21 September 2021

2190140

**Table 1 Summary of Public Submissions and Organisation Submissions**

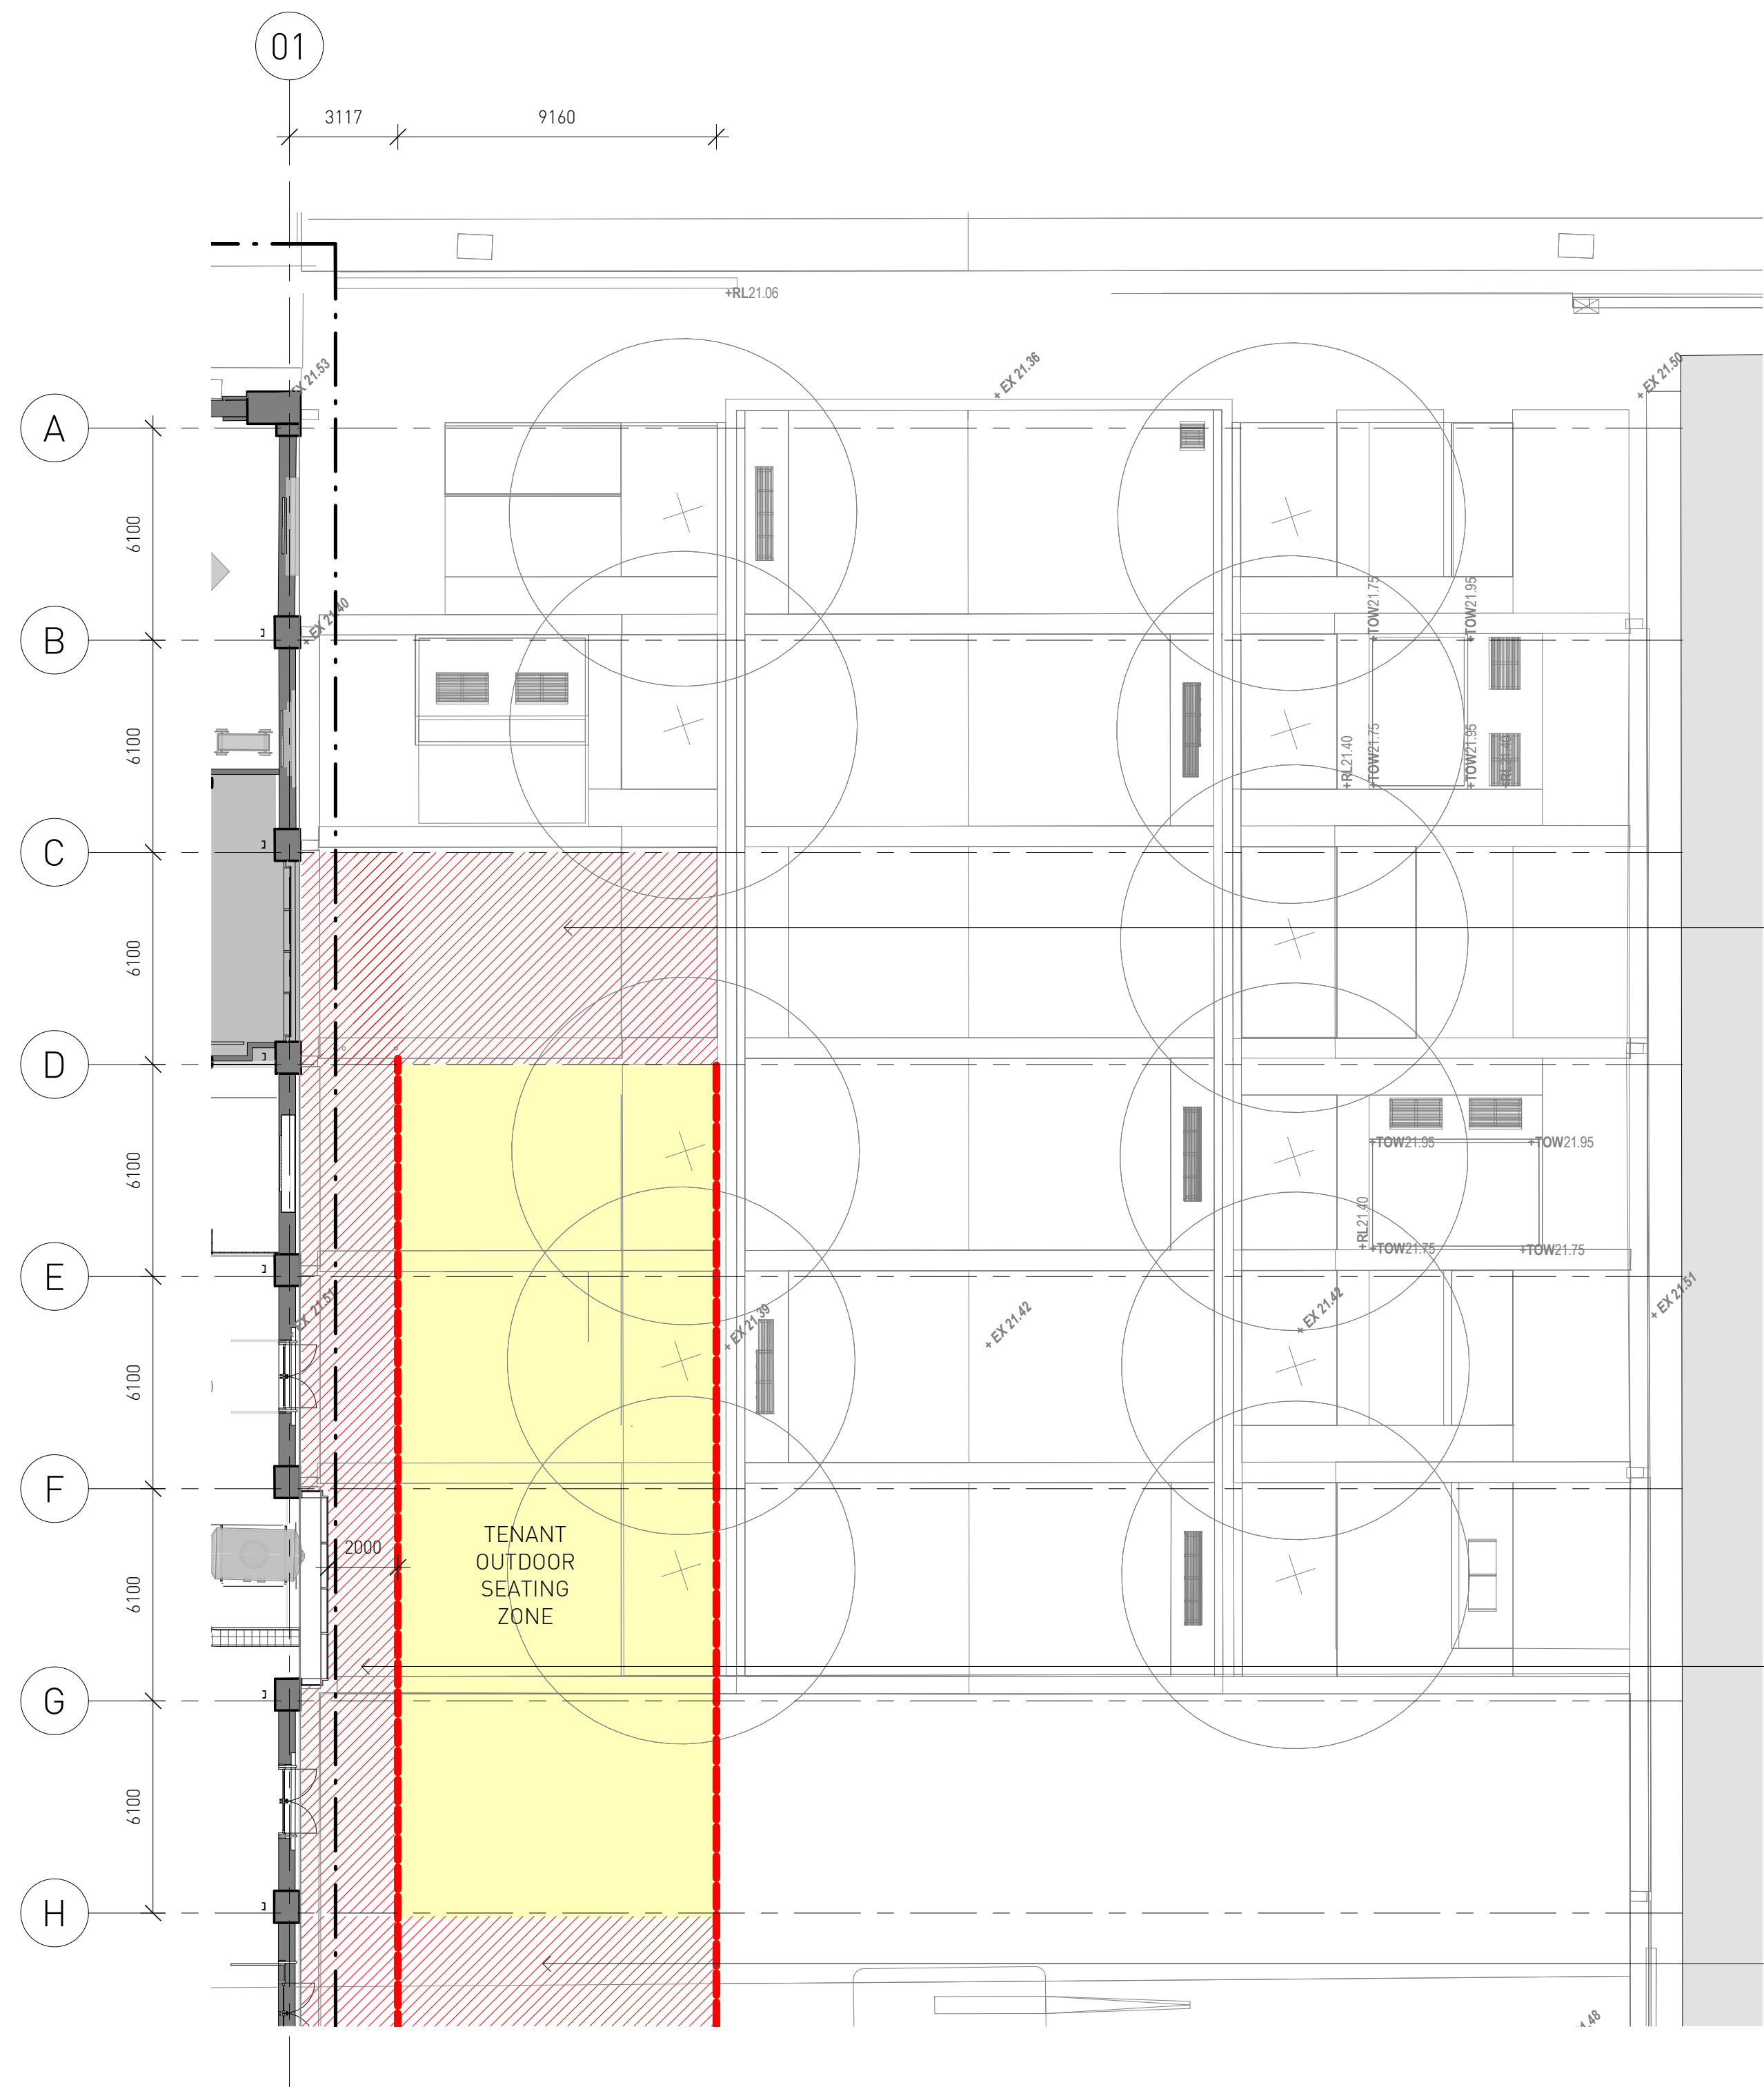
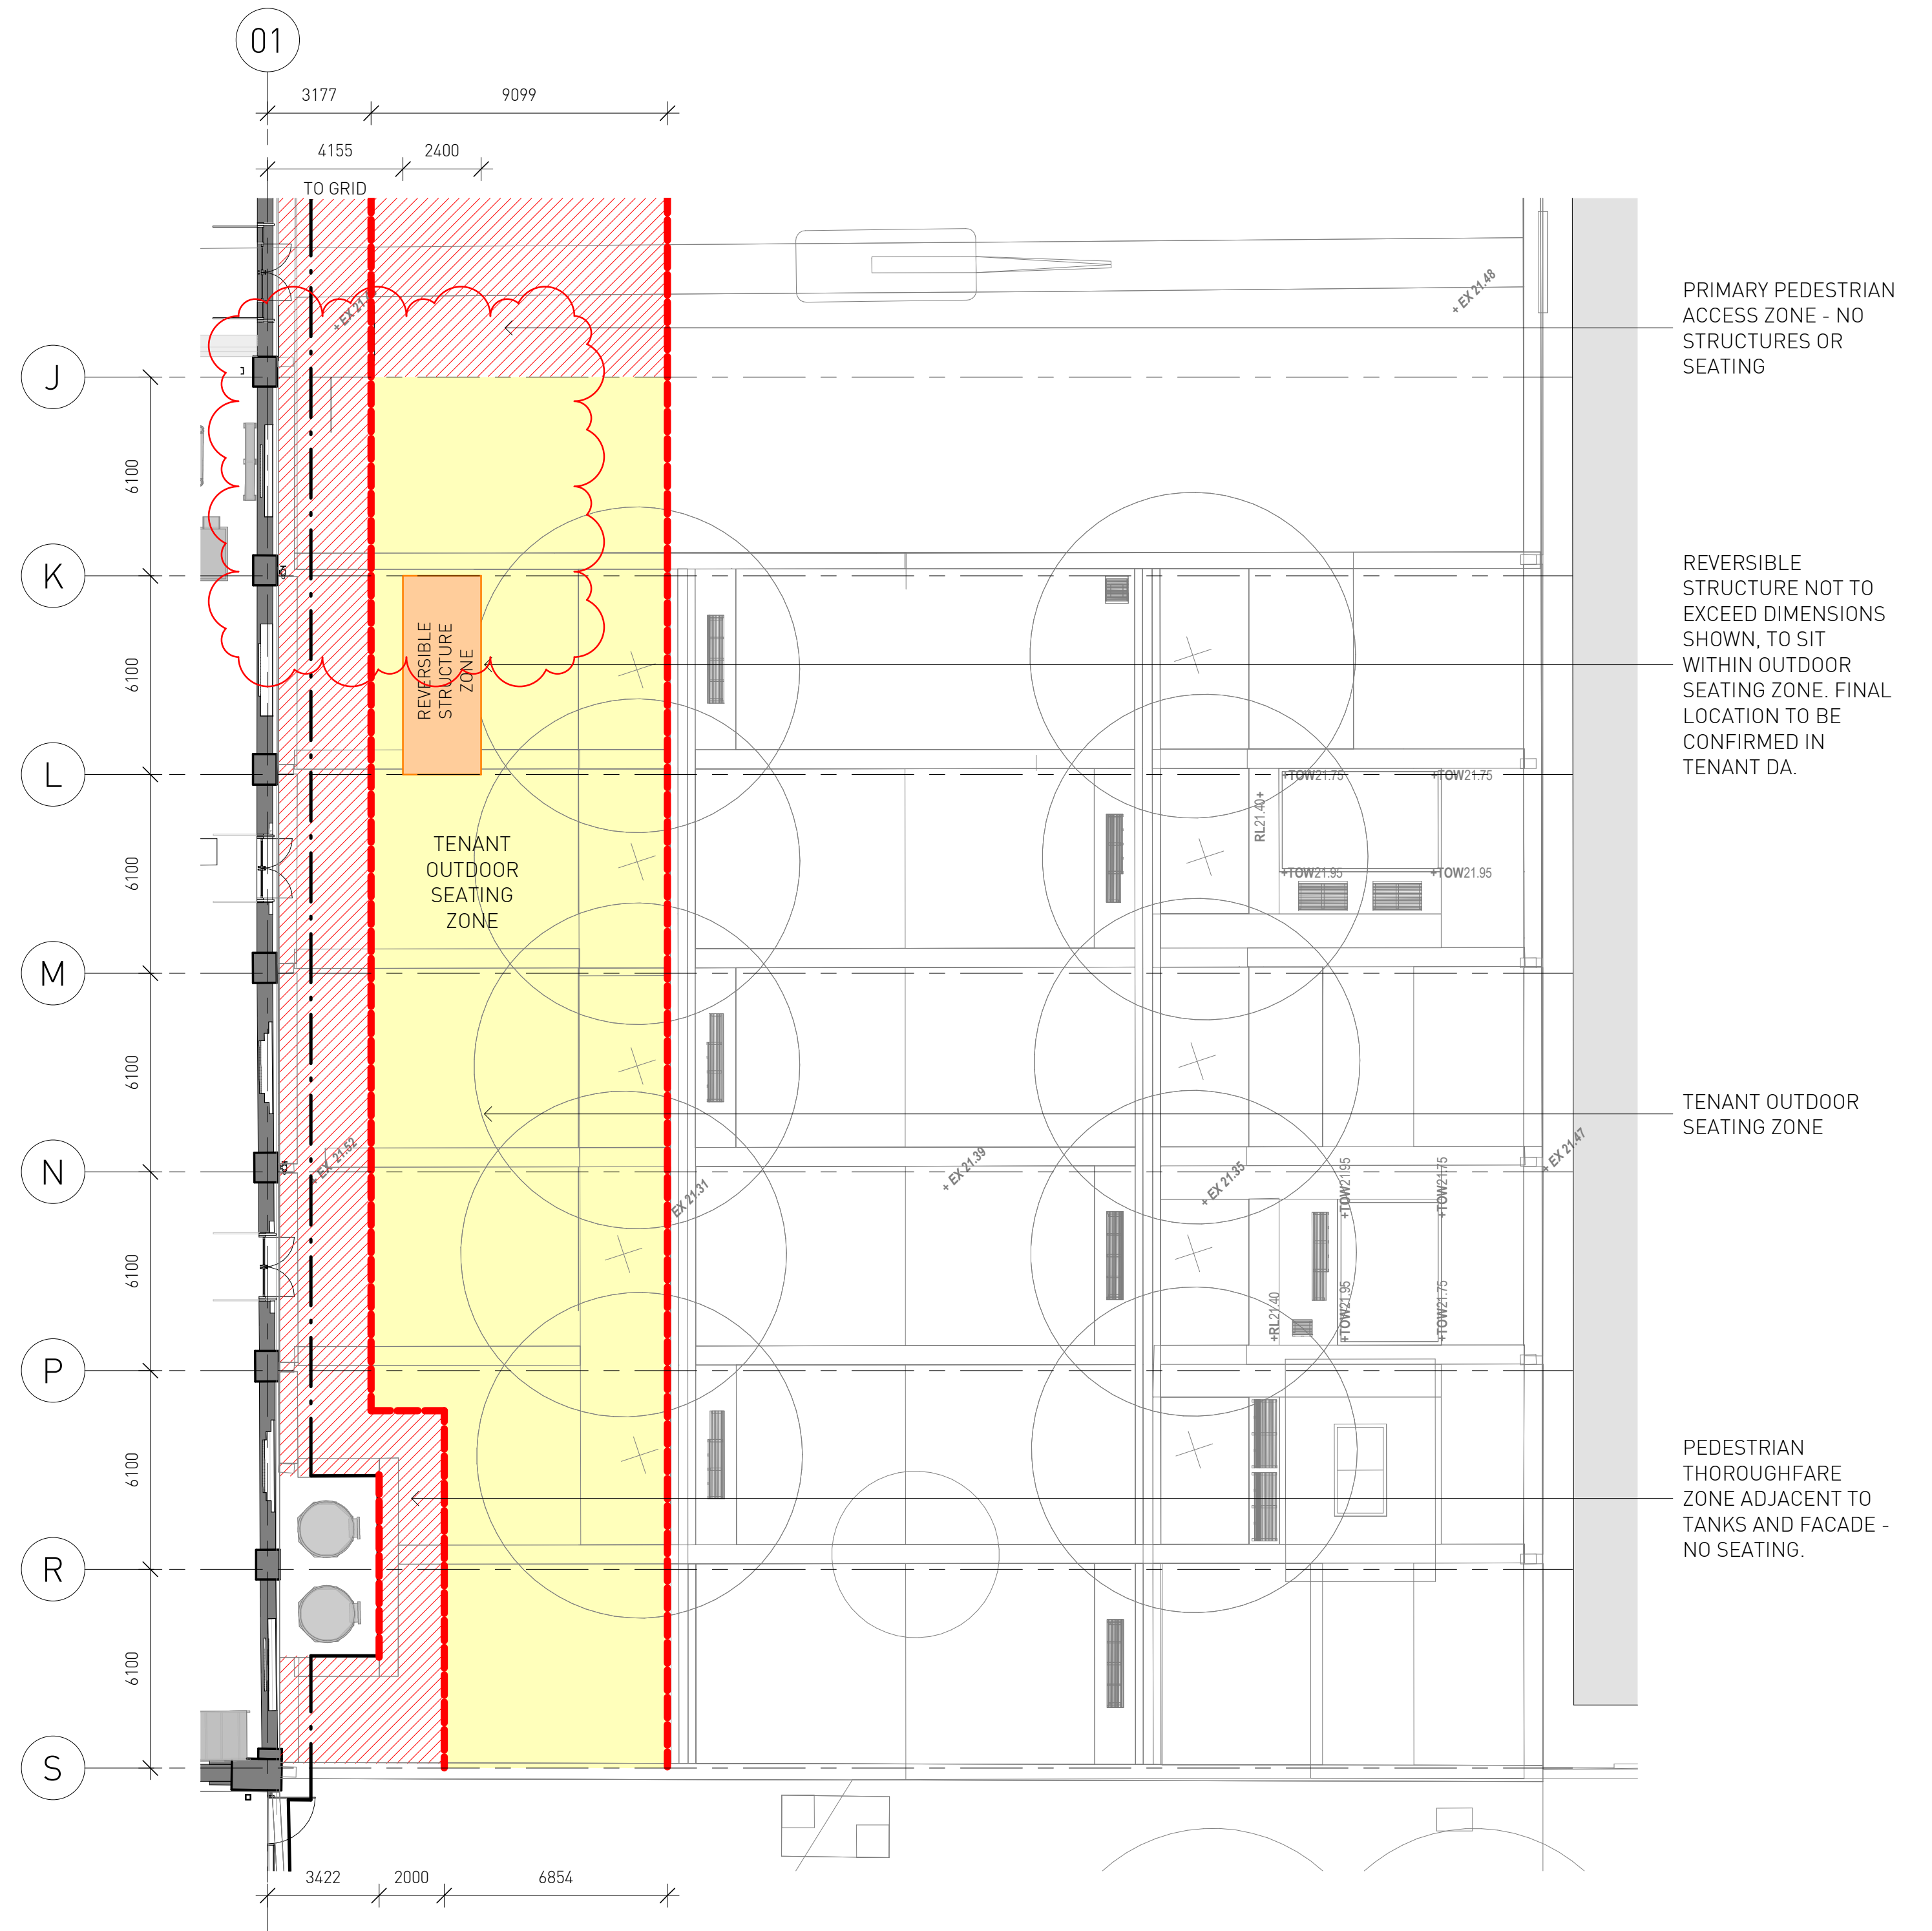
<p>Rail Tram &amp; Bus Union Retired members Association</p> <p><i>...continued</i></p>	<p><b>Revitalising the Public Domain is an urgent necessity</b></p> <p><b>Key Points:</b></p> <p>The documentation for this application contains no quantification of the amount of seating that will be required for the food and beverage premises, no indication of the materials that will be used for the structures and their precise location. These are to be determined in a separate application which does not allow for community participation.</p> <p>There has been scant attention paid to the development of the public domain and in particular Innovation Plaza. It has been all but ignored. The curtilage of the Locomotive Workshops abutting the Plaza has seen expenditures on windows, doors and lighting but Innovation Plaza itself has flown under the radar and its future as a public recreation space has not been the subject of community consultation.</p> <p>The Association argues the neglect of the public domain is a major planning and policy failure and must be urgently rectified. The rejection of this application should be the first step in the process.</p>	<p>The public domain throughout South Eveleigh including Innovation Plaza has been significantly upgraded over the last few years. The works to the public domain were approved under SSD 7317, SSD 8517 and other DAs, and include the general upgrade to the pavement infrastructure, wayfinding signage, provision of new street furniture, the junior scooter park, the children's playground, the Aboriginal Cultural garden, the community garden, the public art works and significant new landscaping throughout. This demonstrates Mirvac's significant commitment to the public domain and whilst the original activation strategy concepts have been scaled back, Mirvac is currently exploring further activation and engaging concepts for Innovation Plaza and the South Eveleigh precinct, for a post Covid 19 situation.</p> <p>Furthermore, all information regarding the number, type and design of the outdoor seating will be part of a separate DA that will be submitted to Council for assessment, however the seating will be moveable, not fixed and will be able to be packed and stored away at the end of every day.</p>
